Addendum No. 1

RE: Contract ID C202605

Carteret County (BK-5128)

Replace Fender System Bridge #6 on NC-58 Over Atlantic Intracoastal Waterway
Between NC-24 and Emerald Isle

REVISIONS						SHEET NO.
NO.	BY:	DATE:	NO.	BY:	DATE:	S-1
1			3			TOTAL SHEETS
2			4			6

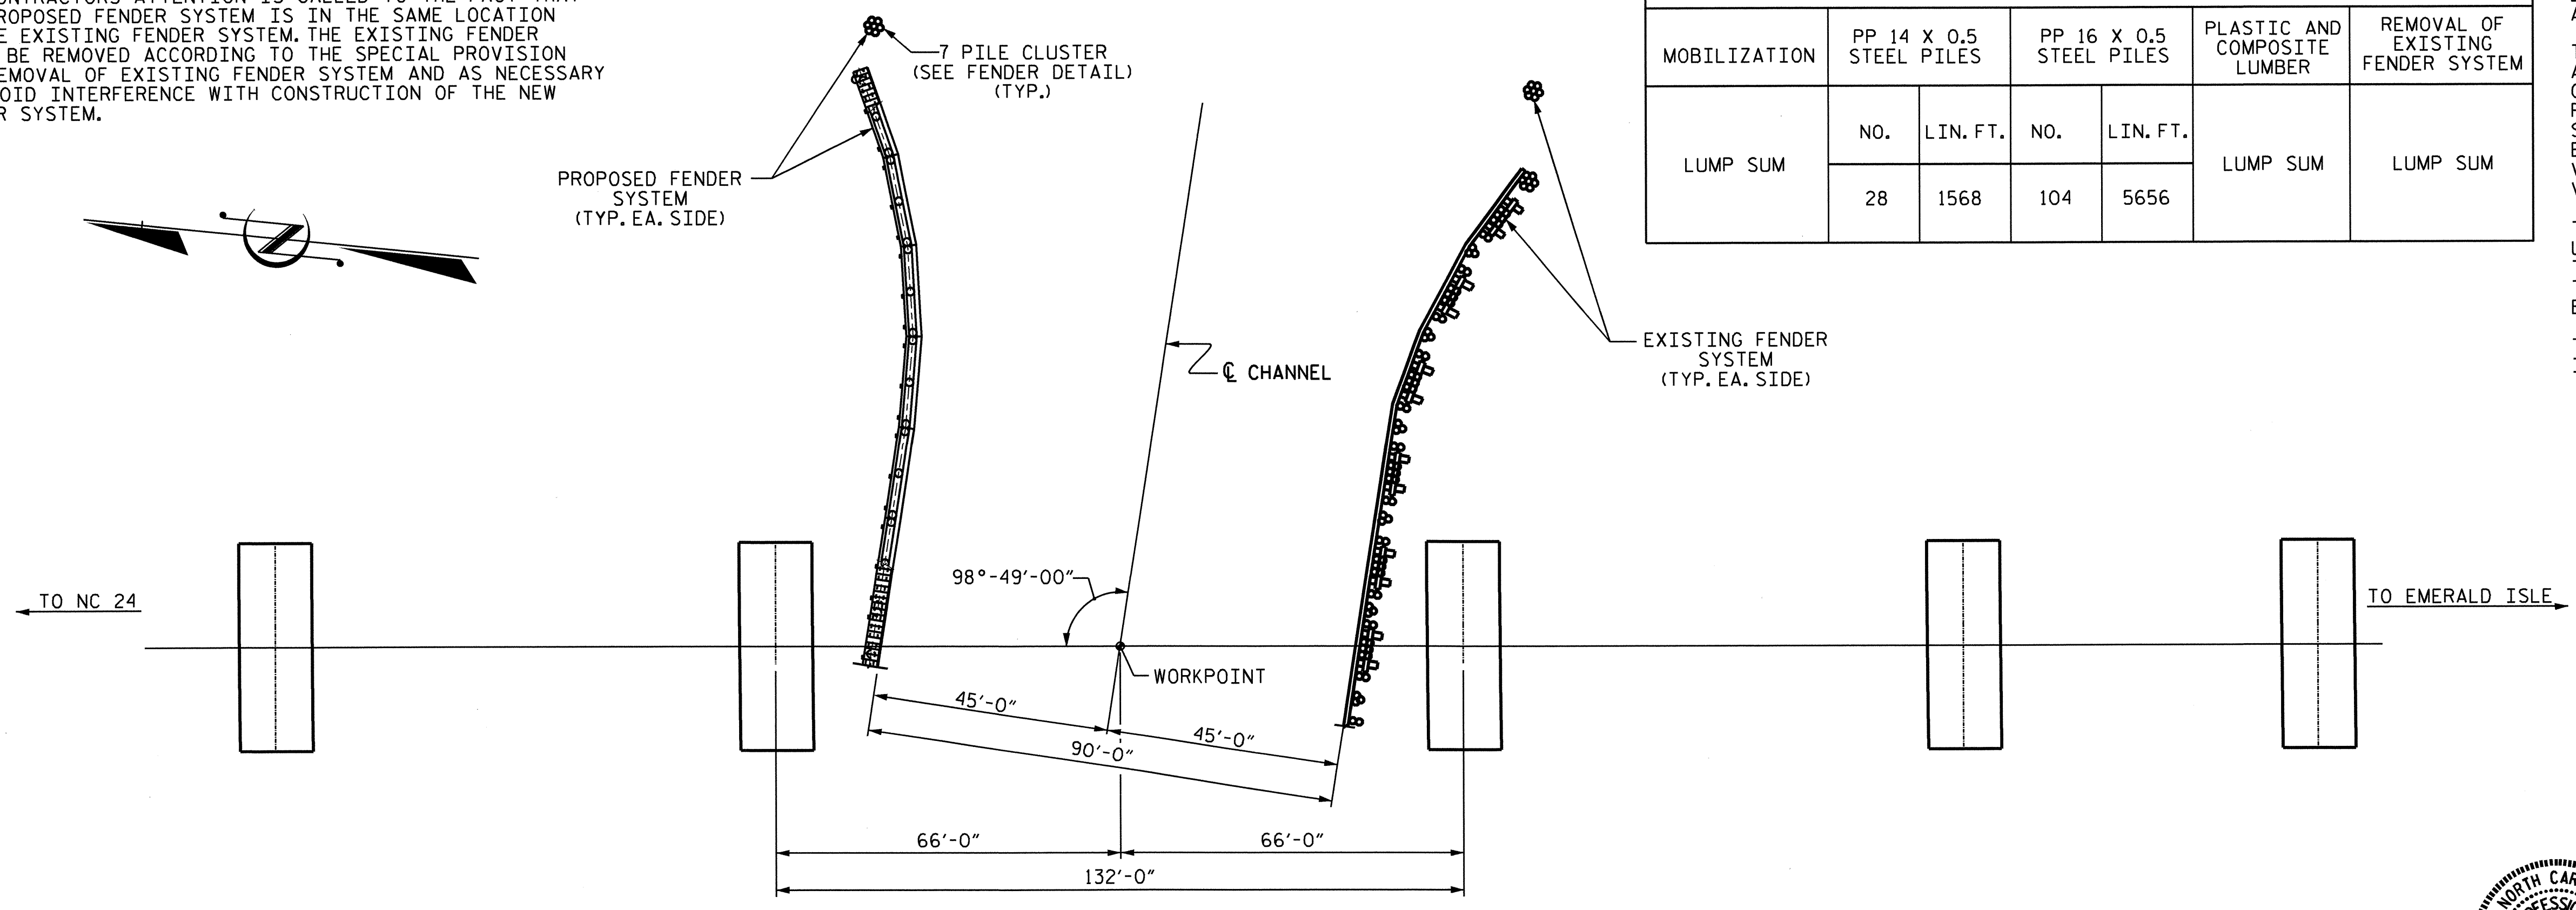
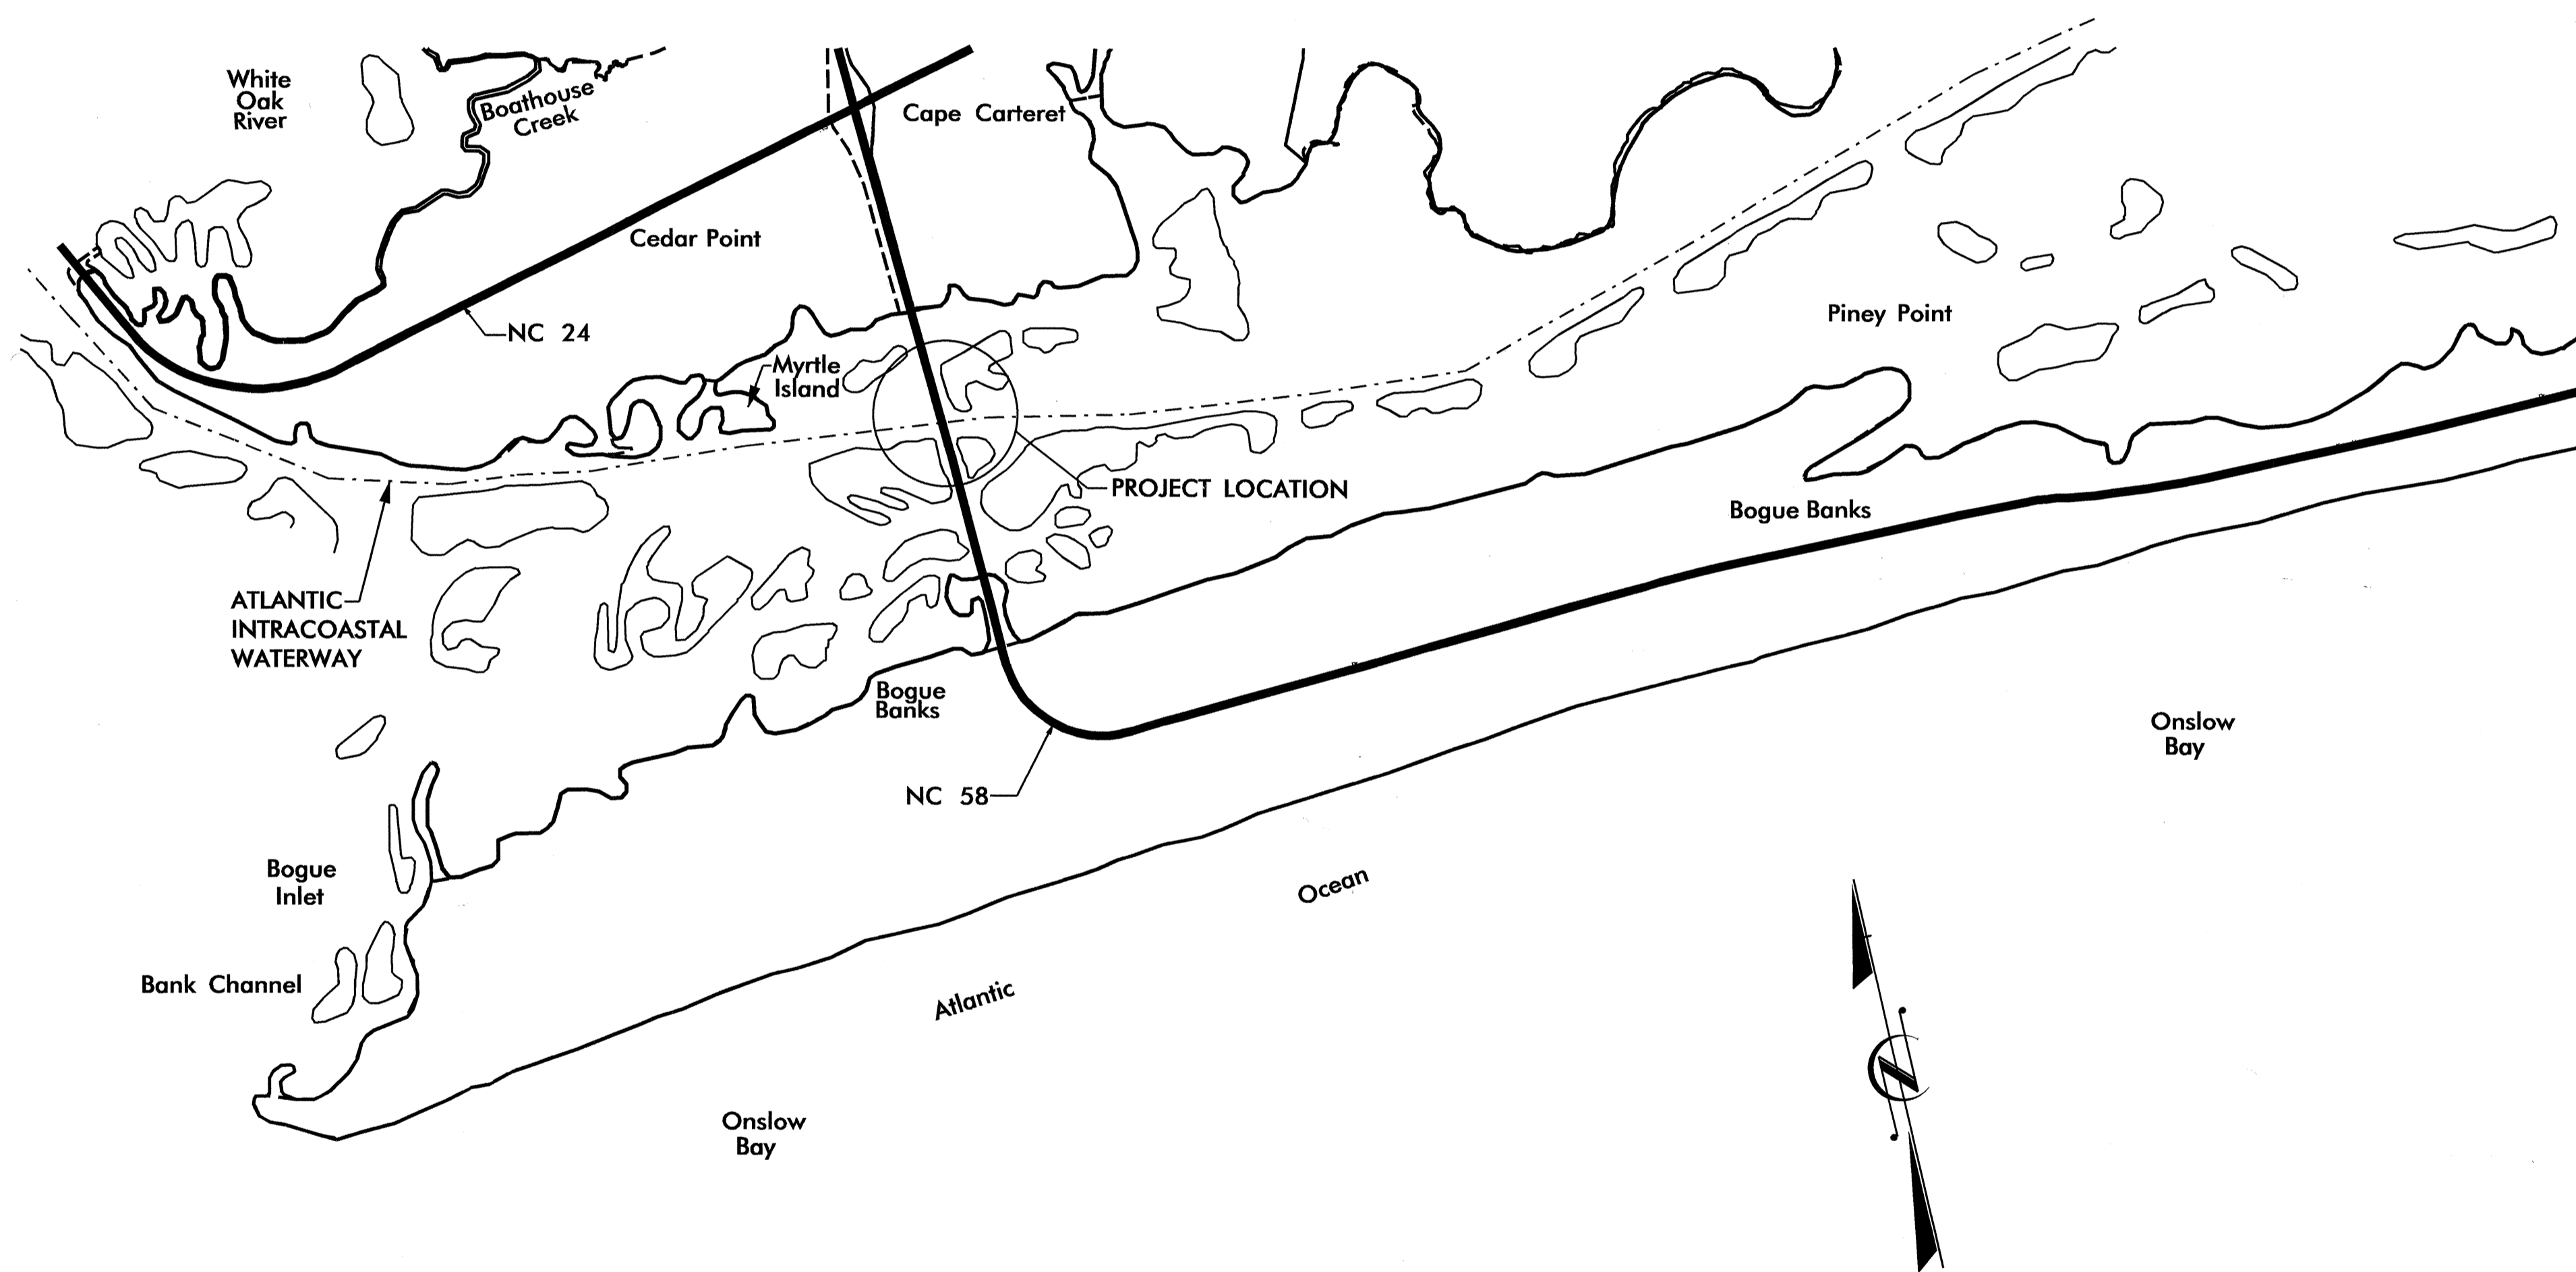
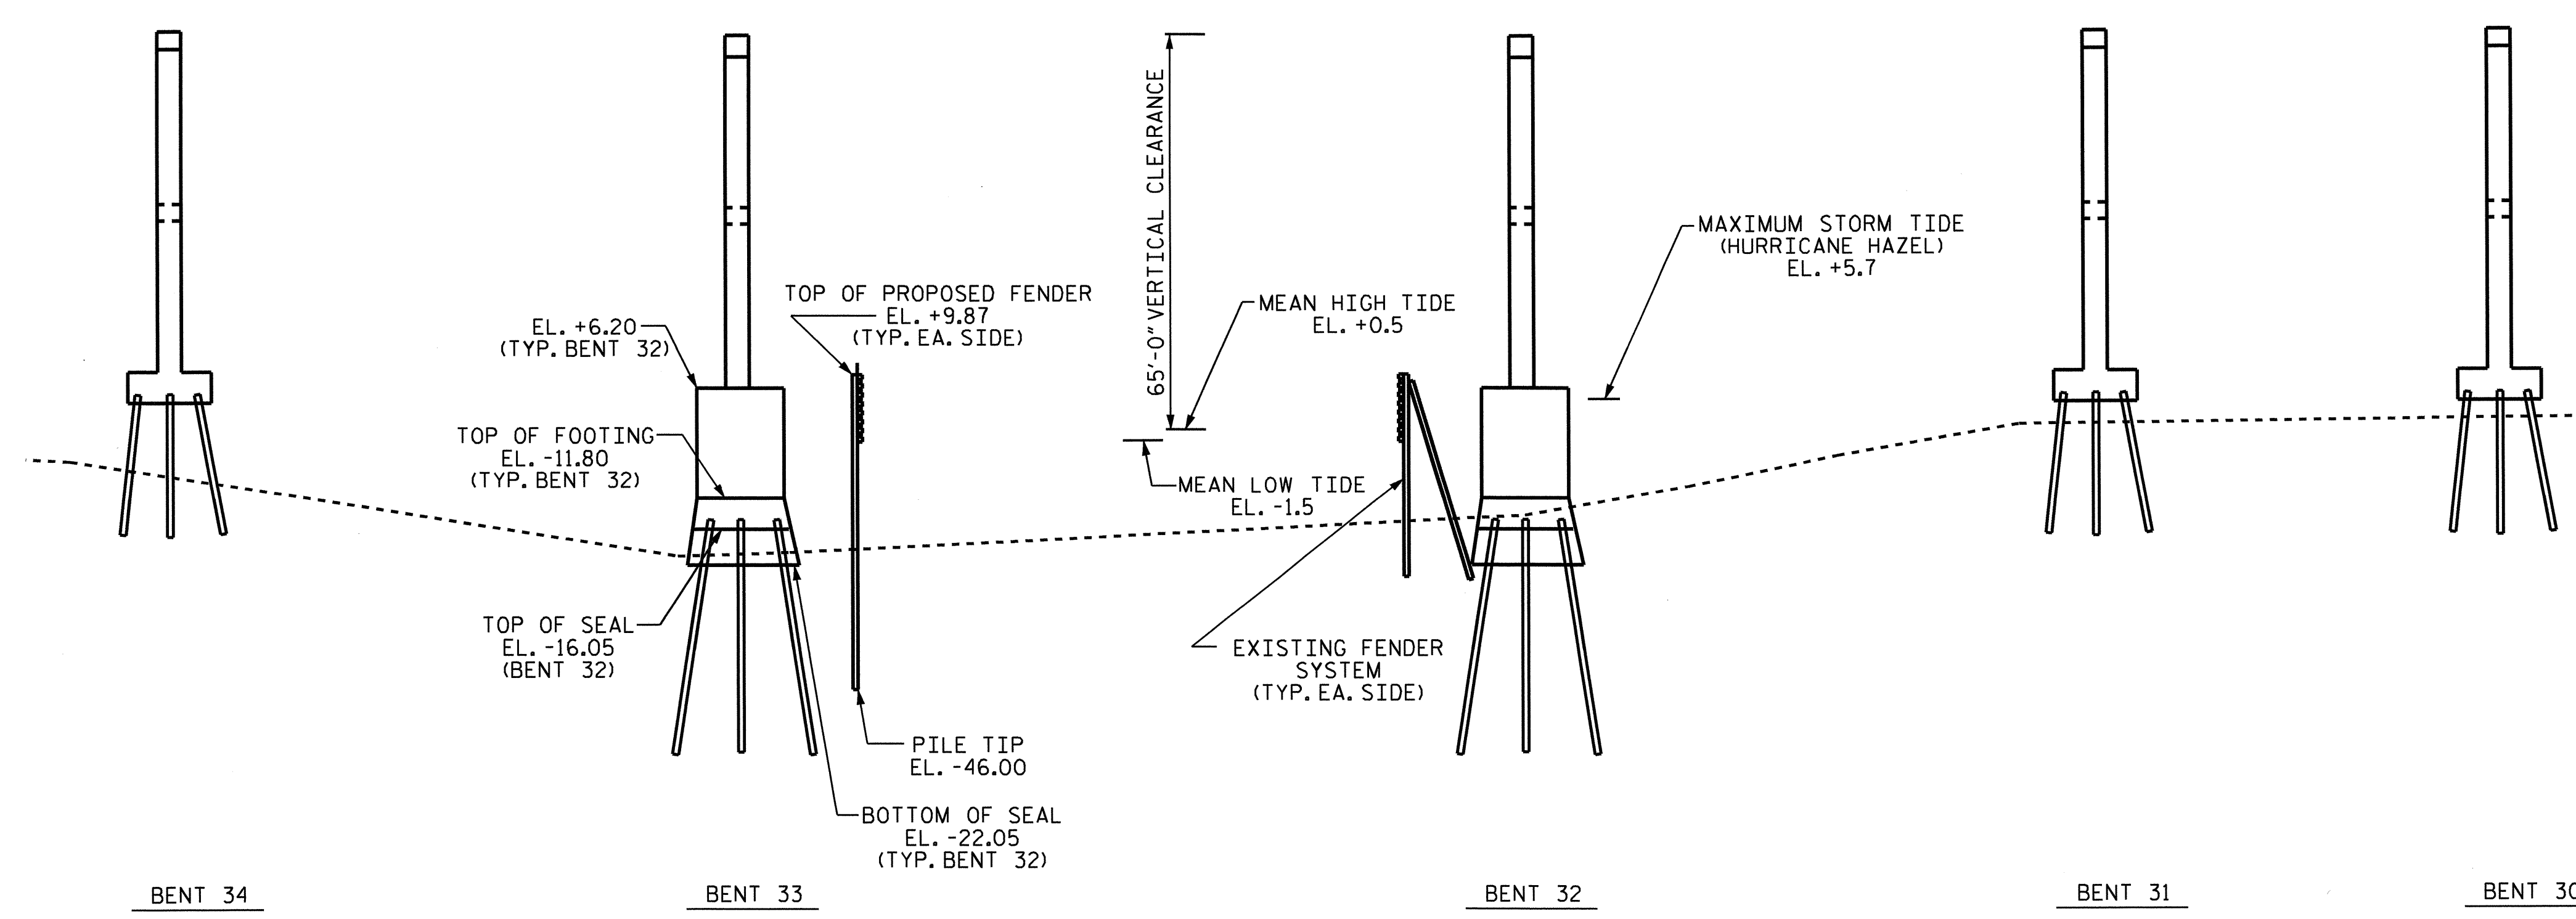
On Sheet S-1 the "Total Bill of Material" and the note concerning the "stainless steel bolts" has been revised. Please void Sheet No. S-1 in your plans and staple the revised Sheet No. S-1 thereto.
